SEXTON RANCH

A REPLAT OF LOT 47 AND LOT 48, CHAPARRAL HILLS, LOCATED IN THE
NORTHEAST QUARTER OF SECTION 36, TOWNSHIP 11 SOUTH, RANGE 67 WEST OF THE 6TH P.M.,
COUNTY OF EL PASO, STATE OF COLORADO

PROJECT NO. 21-005	Drawn By: TSM	Date: 02-11-21
Checked By: TSM	Sheet: 1 of 1

CHAPARRAL HILLS FILING NO. 1B
 A REPLAT OF LOT 47 AND LOT 48, CHAPARRAL HILLS, LOCATED IN THE
 NORTHEAST QUARTER OF SECTION 36, TOWNSHIP 11 SOUTH, RANGE 67 WEST OF THE 6TH P.M.,
 COUNTY OF EL PASO, STATE OF COLORADO

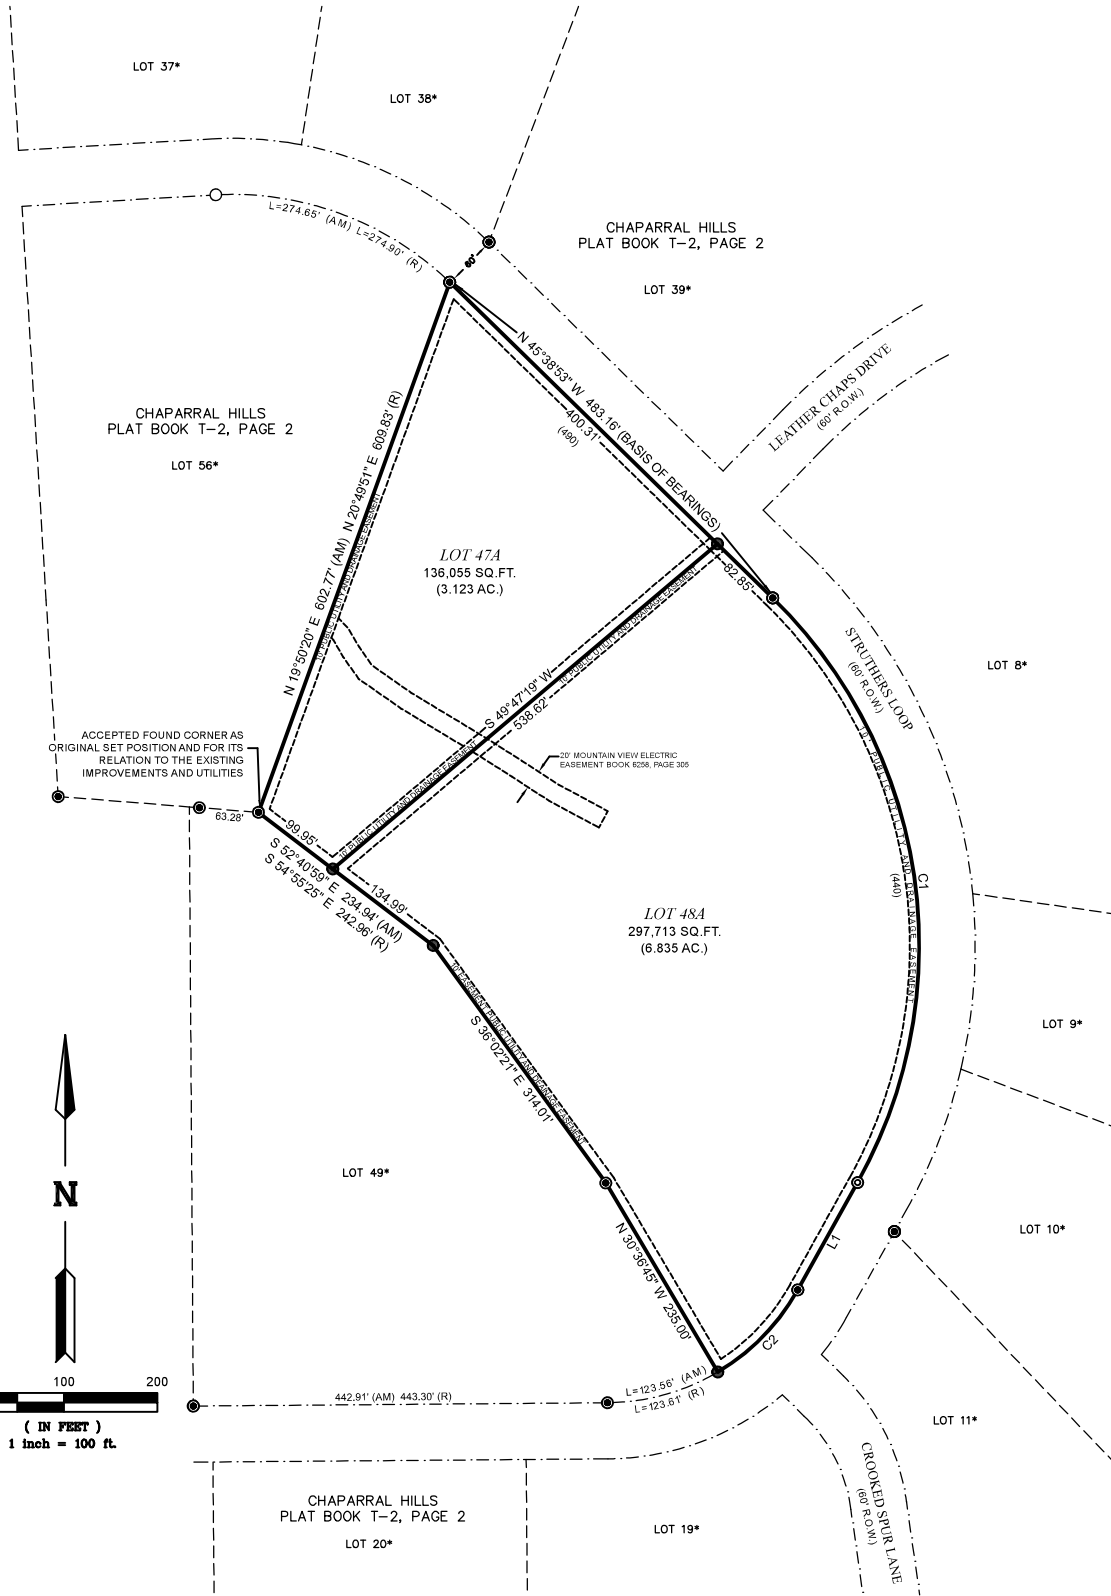
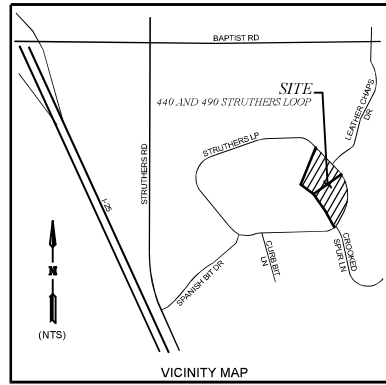
The utility easements are being adjusted. please be aware that the utility companies will need to approve of the relocation and will need to verify that there are no lines in these locations.

When adjusting the common lot between 2 lots, the original lot numbers followed by the letter "A" shall be used to number the new lots (e.g., when realigning the common lot line between lots 7 and 8, the new lots should be numbered 7A and 8A).

Replat names shall be consistent with the name of the original plat filing unless the land includes more than 1 plat name, and characterized by an alphabetic descriptor after the filing number, and shall reflect consistency with the order of the original filing.

there is a mortgage holder. they need to either be signatory to this action or you will need to provide a ratification statement at the time of recording.

Edit note 5 to reflect verbiage below:

A statement by the land surveyor explaining the basis of bearing. Assumed bearings shall not be used. The existing monuments that define the reference line shall be included on the exemption plat. One of the following methods of establishing a basis of bearing shall be used: (1) solar or polaris observation - the date of the observation and the method used shall be included in the basis of bearing note; or (2) GPS observations on the monuments at each end of the reference line. (Note: The observations shall be of sufficient time to ensure an accurate bearing. The methodology and length of the observation session shall be included in the basis of bearing note).

Please revise note 10 to reflect verbiage below:

If the property is served by a well, then we will need the following note to be added to the plat:

Add " PCD File No. VR-21-003".

This property is not located within a designated FEMA Floodplain as determined by the Flood Insurance Rate Map, Community Map Number _____, effective date ____ (modification when LOMR has been approved) and as amended by the FEMA approved Letter of Map Revision (LOMR) case number _____ dated _____.

Sewage treatment is the responsibility of each individual property owner. The El Paso County Department of Health and Environment must approve each system and, in some cases the Department may require an engineer designed system prior to permit approval. These systems may cost more to design, install, and maintain. Soils and Geology conditions on site require that all (or certain lots) On-Site Wastewater Systems shall be located and designed by a Professional Engineer, currently registered in the State of Colorado. (Note: this note used in special cases only when requested by the Health Department or pursuant to a condition of approval)

Individual wells are the responsibility of each property owner. Permits for individual wells must be obtained from the State Engineer who by law has the authority to set conditions for the issuance of these permits.
